Land off Roslyn Avenue,
Netherton, Huddersfield

Stage 1 Road Safety Audit

CLIENT: Harron Homes
PROJECT TITLE: Land off Roslyn Avenue
 Netherton, Huddersfield
REPORT TITLE: Stage 1 Road Safety Audit
PROJECT REFERENCE: 400187
DOCUMENT NUMBER: 001
ISSUE NUMBER: 01
DATE: March 2026

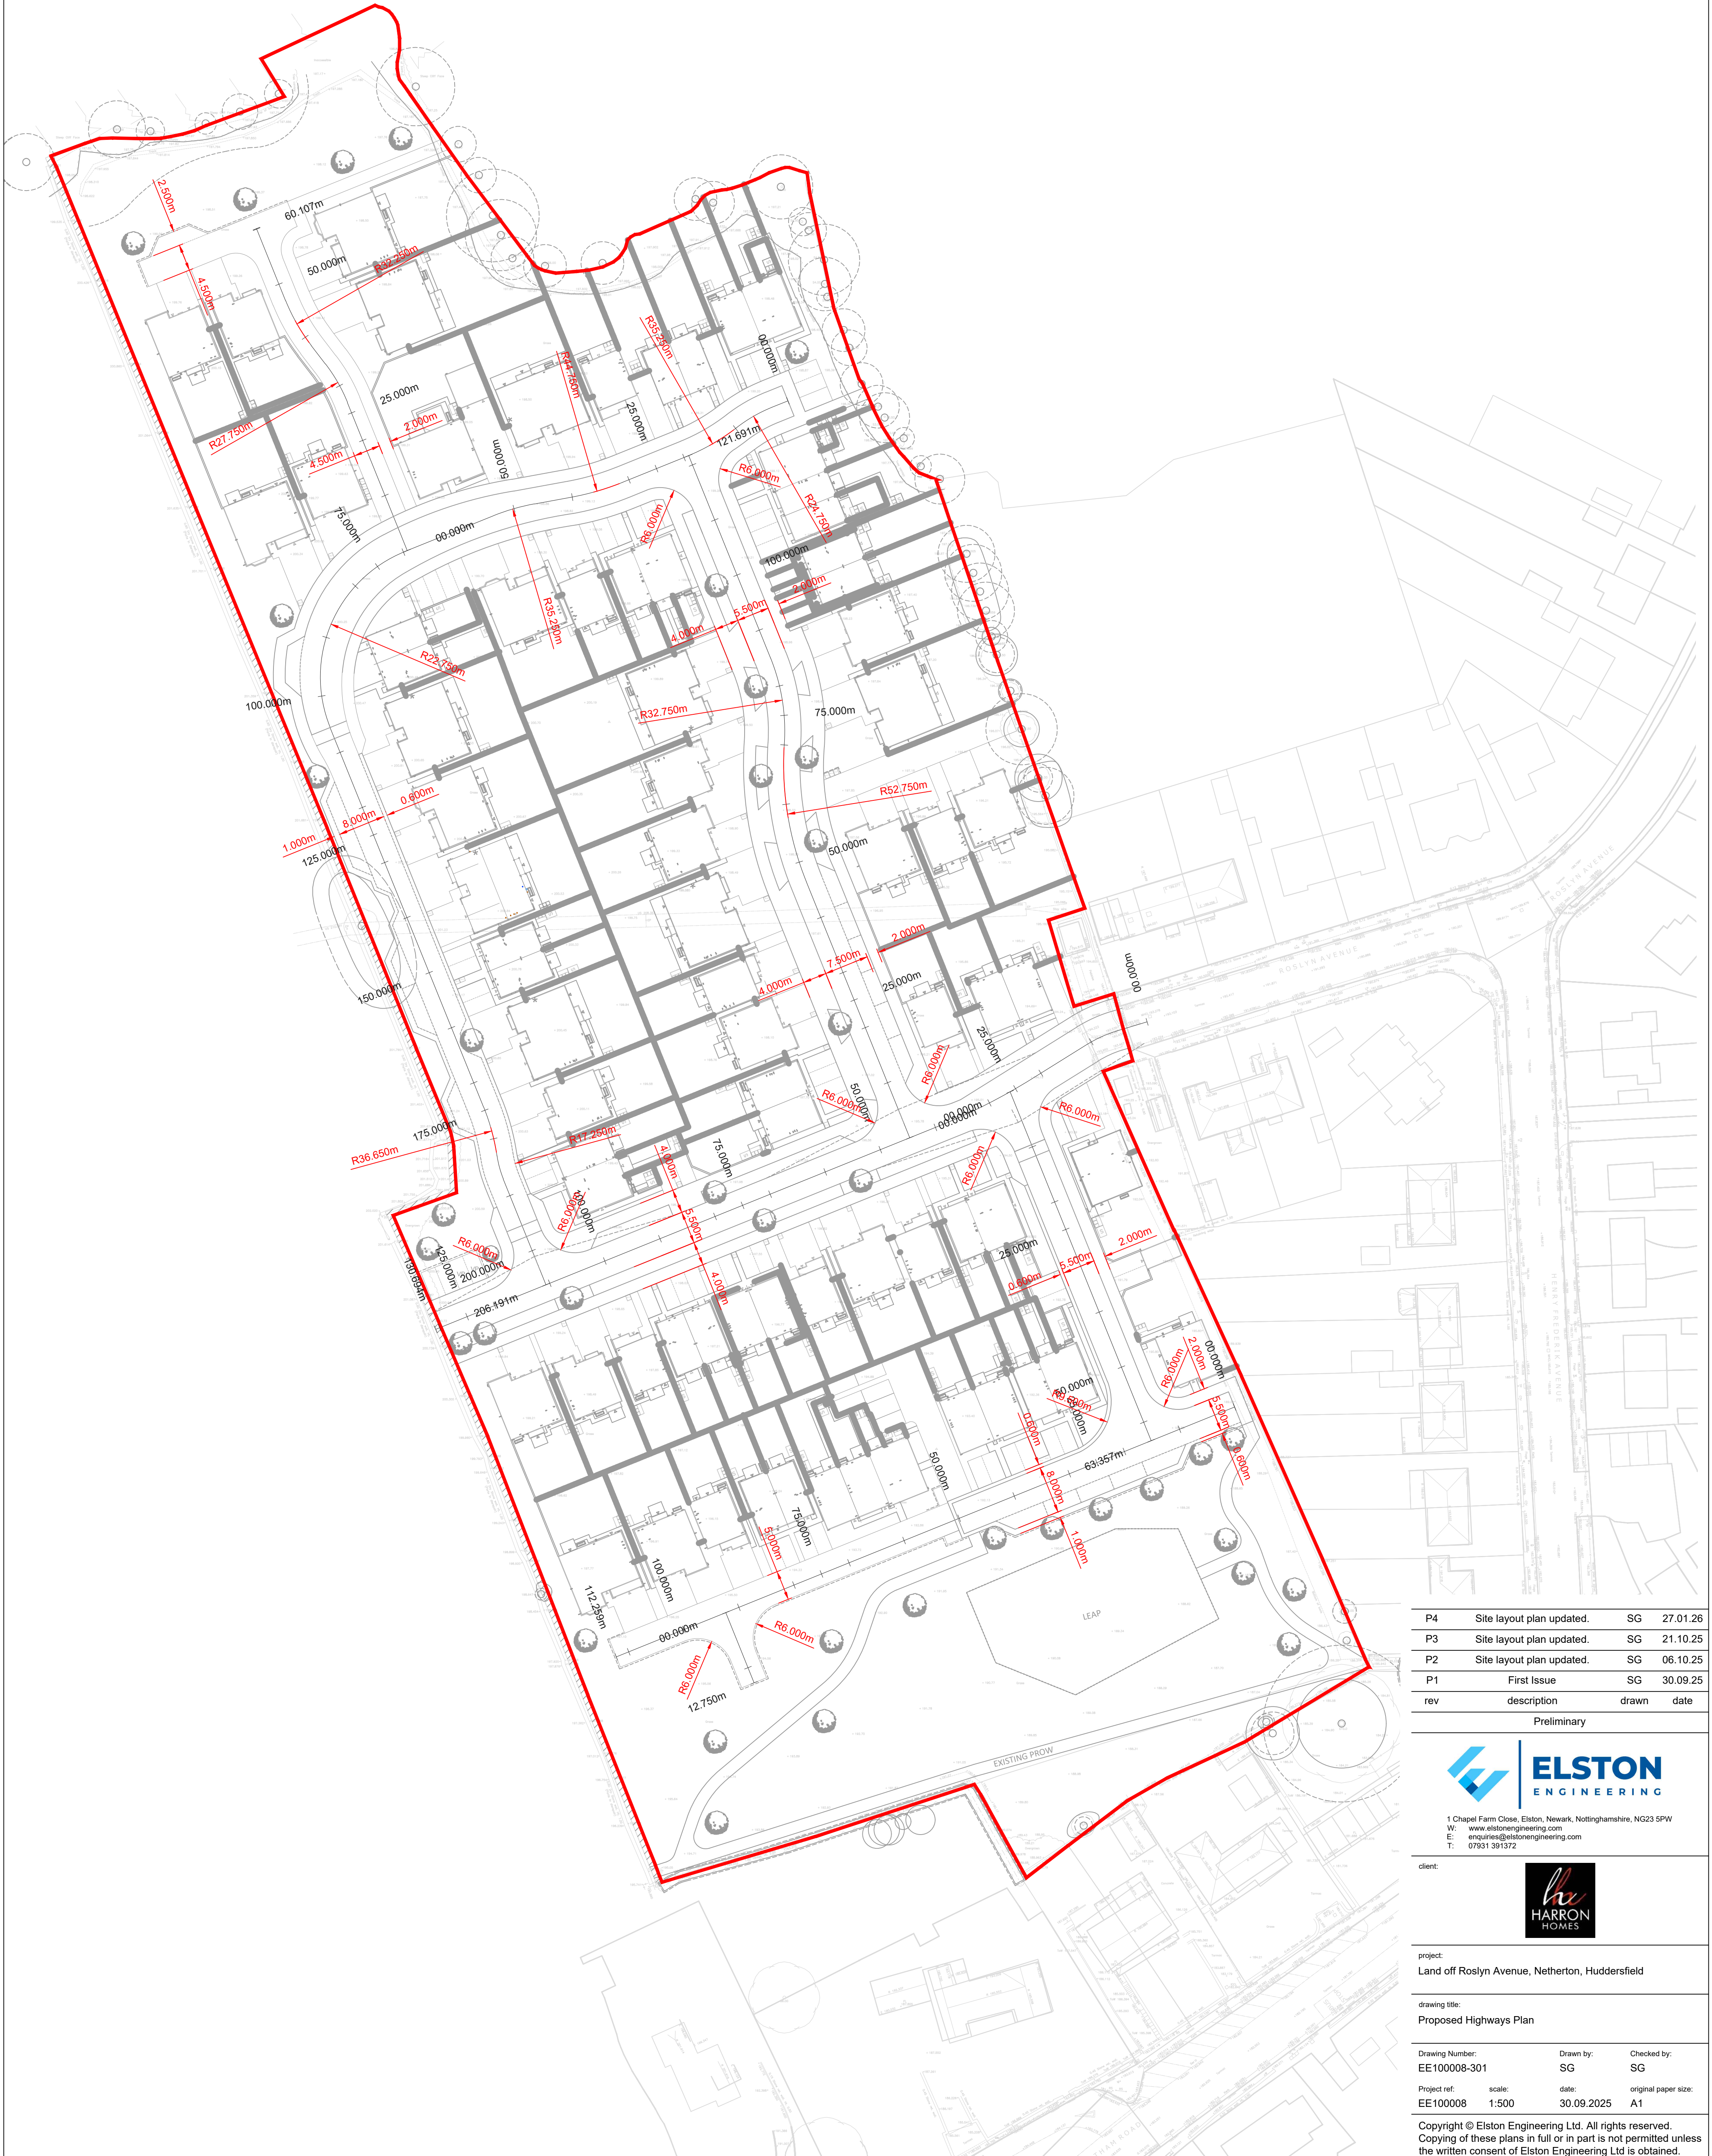
Location: Junction adjacent to Plot 67.

Summary: Lack of dropped crossing.

Detail: Proposed dropped kerb pedestrian crossing facilities are indicated on the Section 38 Layout Plan at the majority of significant junctions within the development. However, no dropped crossing provision is shown at the junction located at the north-east end of the loop road. There is a footpath link to and from the development adjacent to Plot 67 that connects to this junction, which is likely to generate pedestrian movements across the carriageway at this location. The absence of a dropped crossing may therefore result in an inconsistent level of pedestrian provision and may create difficulties for mobility-impaired users, wheelchair users, and those with pushchairs attempting to cross the carriageway. This may discourage pedestrians from using the footway network as intended or lead to informal crossing at locations without appropriate tactile paving or level access.

Recommendation: It is recommended that a dropped kerb pedestrian crossing point be included in the design at this junction including appropriate tactile paving.
